Byers Gill Solar Farm NSIP – JSJV Review

Prepared for: Chris Bell (National Highways)
Prepared by: Jonathan Parsons
Date: 28 March 2024
Case Reference: DevTW0138
Document Reference: TM002
Reviewed/approved by: Richard Edwards

The Jacobs Systra Joint Venture [JSJV] have been tasked by National Highways to review documentation produced in support of the Nationally Significant Infrastructure Project [NSIP] known as Byers Gill Solar Farm (reference: EN010139).

Appendix D Percentage Change Network Diagram

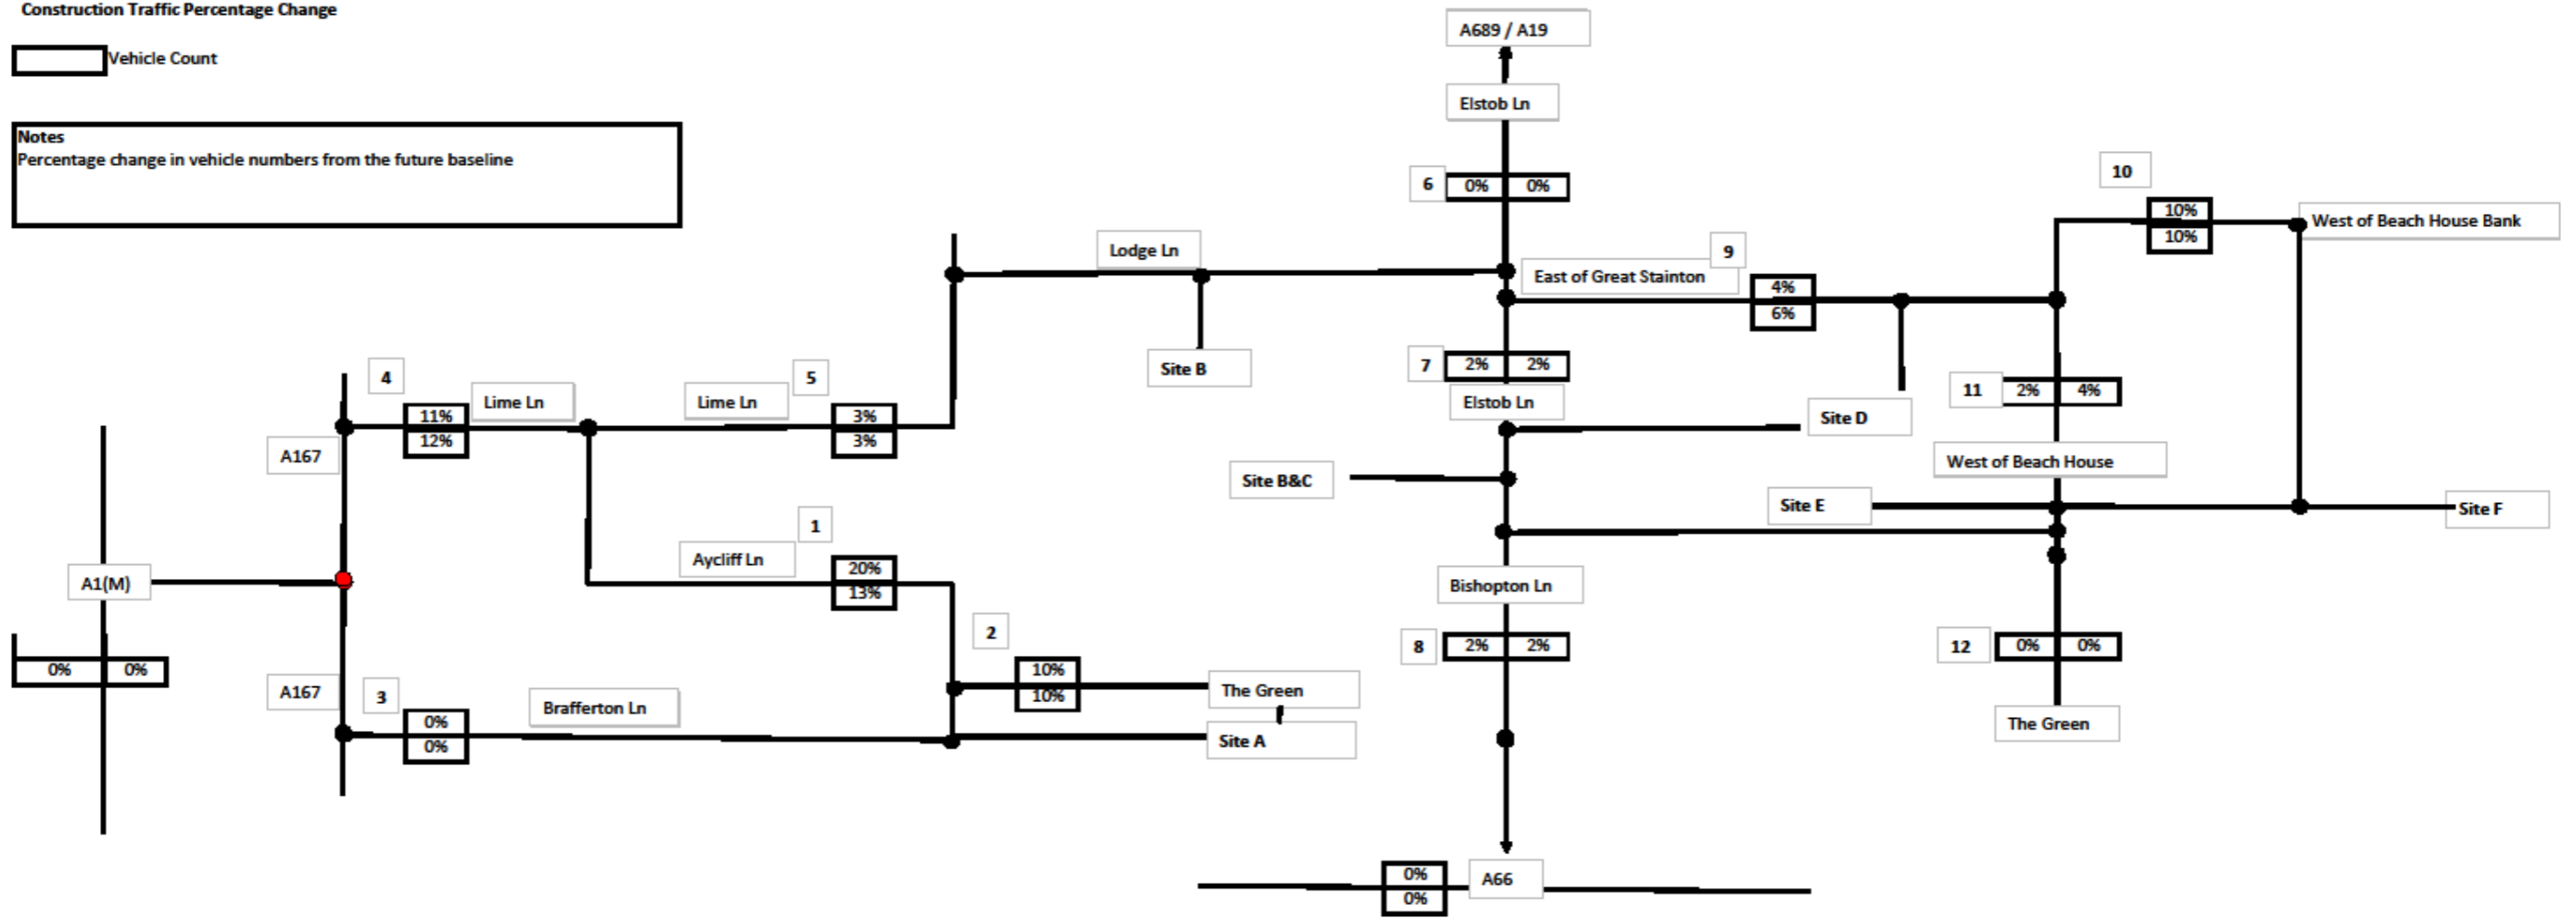
Furthermore, the TS states that the network diagram of the percentage change impact of the development proposals' construction trips on the future baseline can be seen in Appendix D of the TS and that during the construction phase, the majority of roads within the study area see an increase of less than 10%.

Having reviewed the network diagram, from the information presented, it is apparent that the construction trips generated will not have a significant impact at the SRN, notwithstanding the issues JSJV has already raised regarding this element of the trip generation.
